RE: SSD 8378 – Gledswood Hills Public School

WaterNSW has reviewed the Environmental Impact Statement (EIS) and associated documents. The key factors for WaterNSW with regard to this project relate to stormwater management and erosion and sediment controls.

WaterNSW provides the following comments specific to this development:

STORMWATER MANAGEMENT
PLAN - SHEET 2

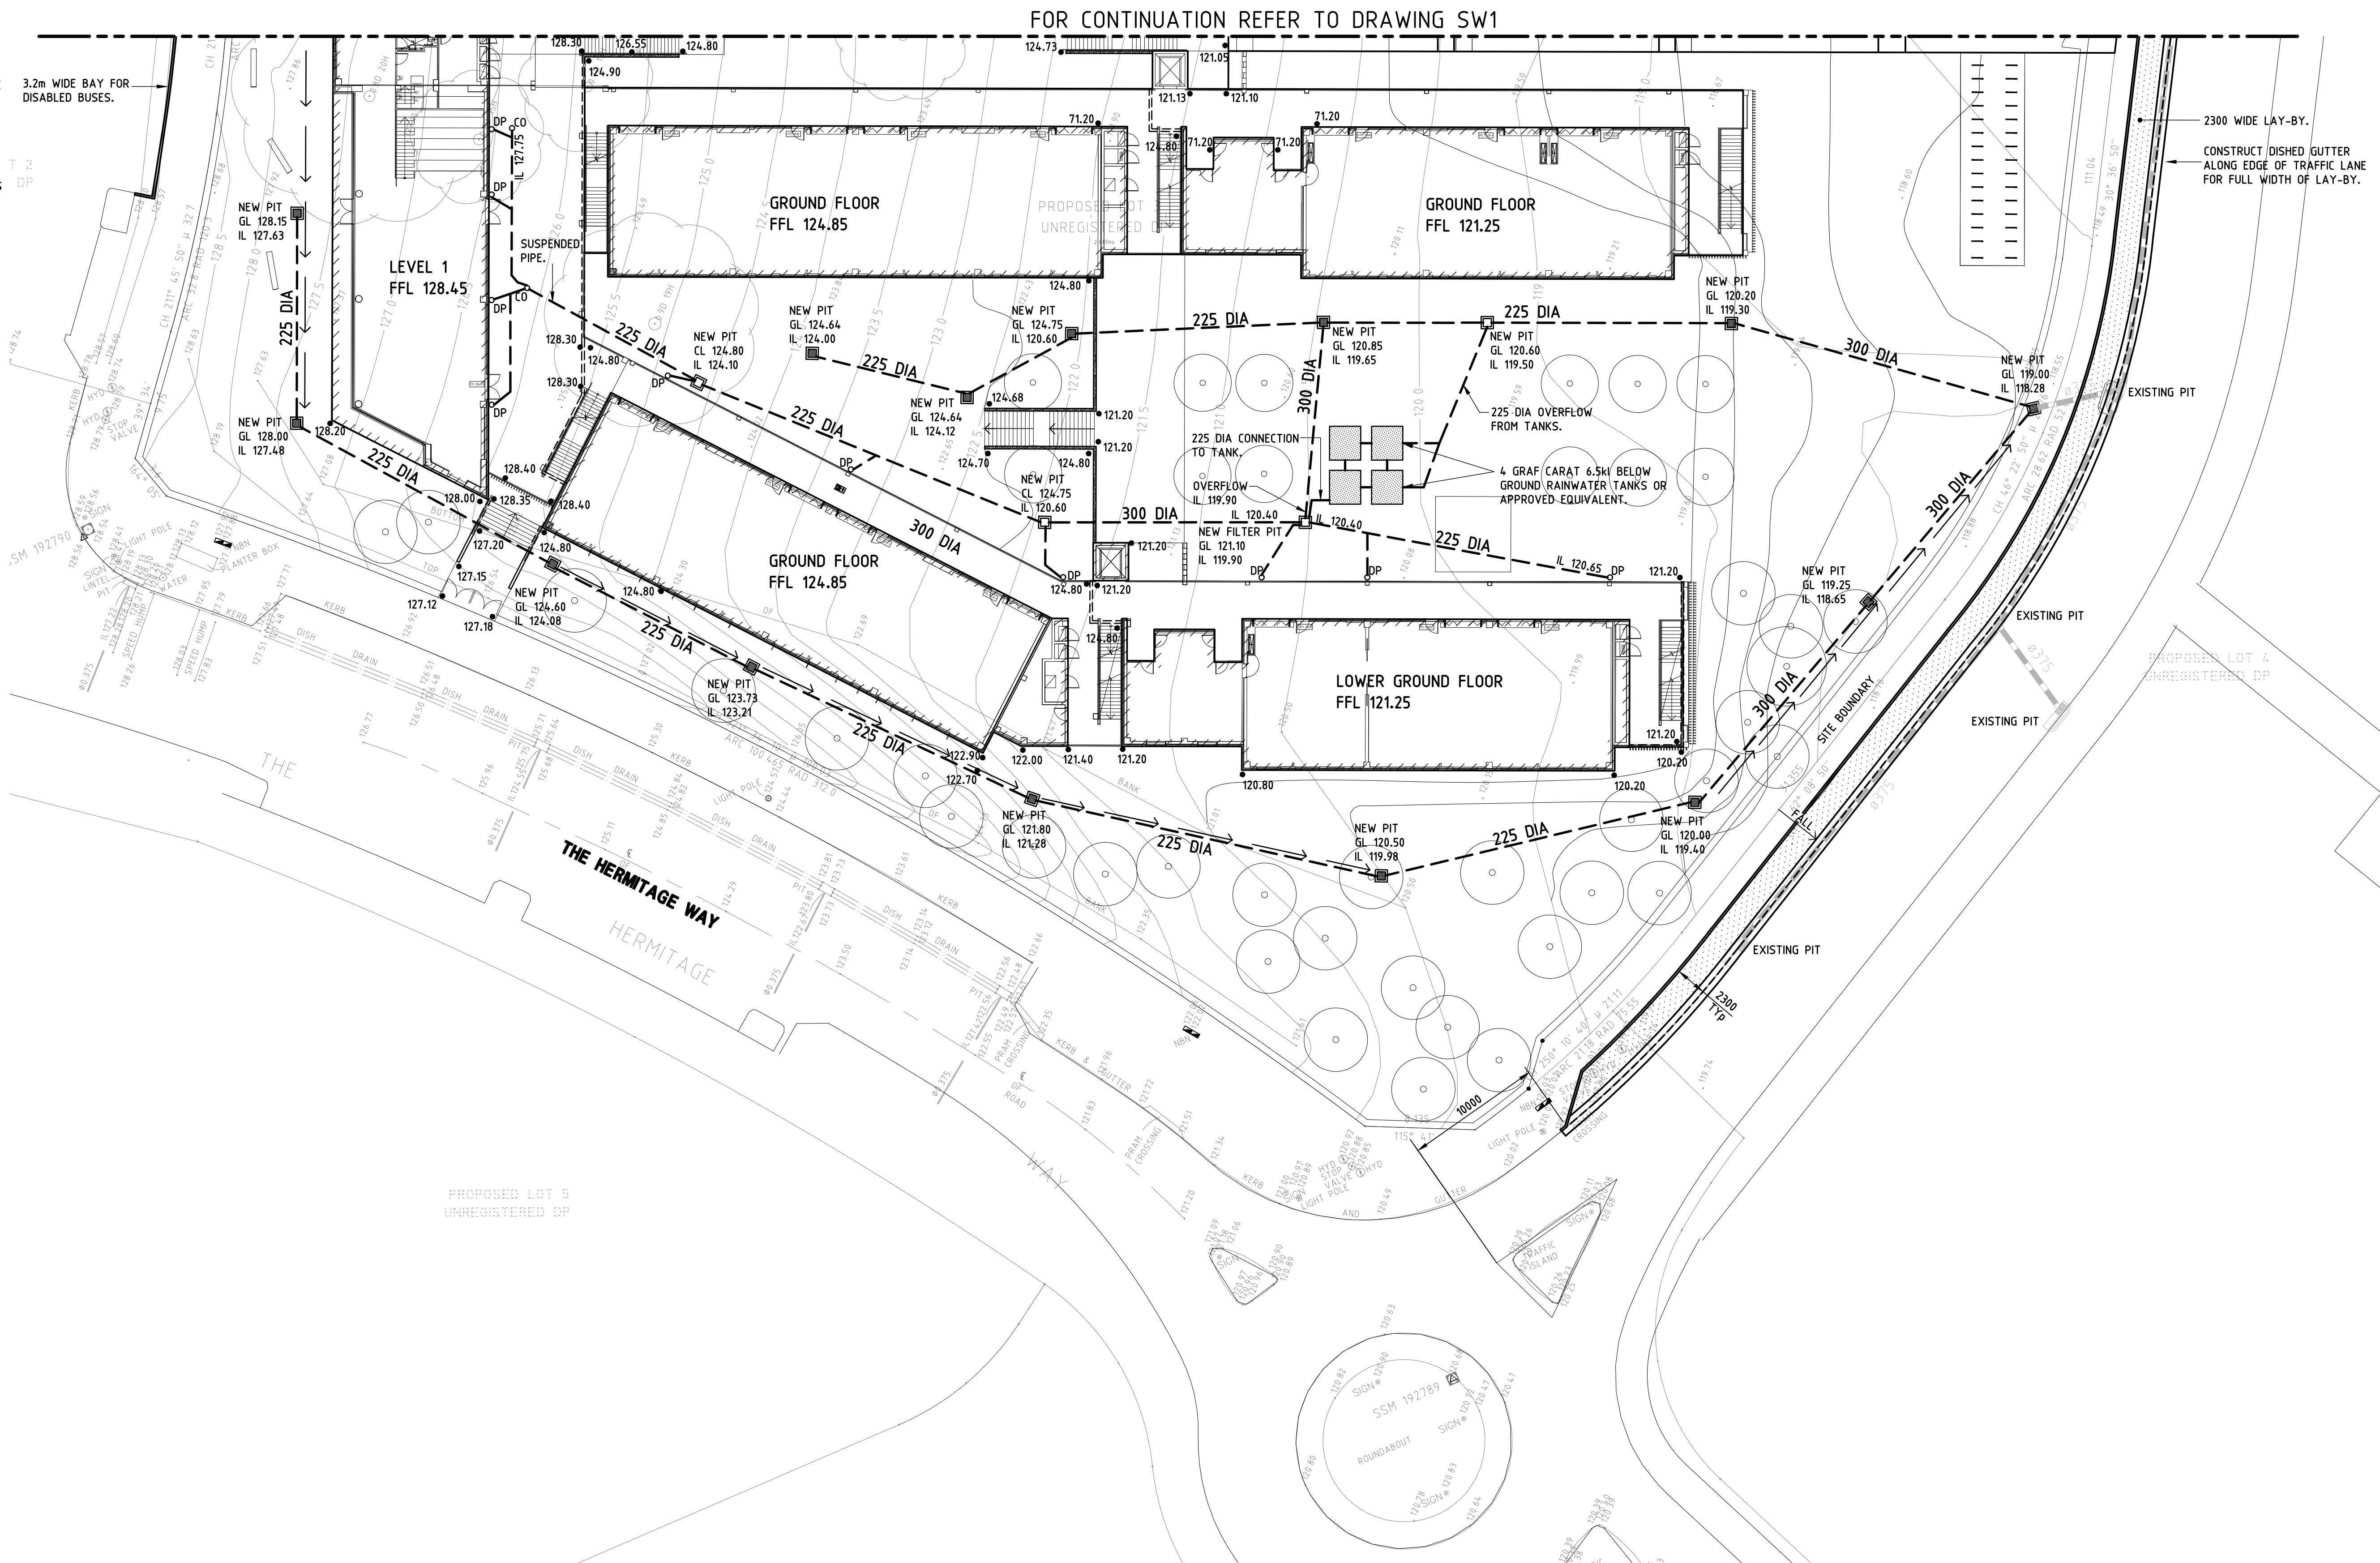
WaterNSW considers the construction of the neighbouring Stage 18 sediment basin and raingarden should occur prior to construction of the Gledswood Hills Public School. However, WaterNSW remains concerned regarding the basin's outlet pipe, shown directing concentrated water flows from the basin into the Upper Canal corridor. WaterNSW has consistently raised the need to prevent sedimentation build up and any potential overflows from the Stage 18 sediment basin, and further information has been requested from Camden Council. Neighbouring developments must be designed and constructed in a manner that prevent pollutants entering the Upper Canal corridor, consistent with section 13(1)(b) of the Water NSW Regulation 2013, and avoid any increase in stormwater entering WaterNSW land.

- The stormwater management system (including Stage 18 sediment basin and raingarden) serving the subject site shall be designed and constructed to ensure that there is no increase in stormwater entering the Upper Canal corridor and the development does not impede stormwater draining from the Upper Canal corridor.
- Effective erosion and sediment controls shall be installed around the works site and stockpiles to prevent construction sediment entering the Stage 18 sediment basin and raingarden which are upslope of the Upper Canal corridor. The controls shall be regularly maintained throughout the construction period and maintained until the development site is stabilised.
- Adequate measures shall be implemented to suppress dust and minimise the potential for dust to enter the open waters of the Upper Canal.
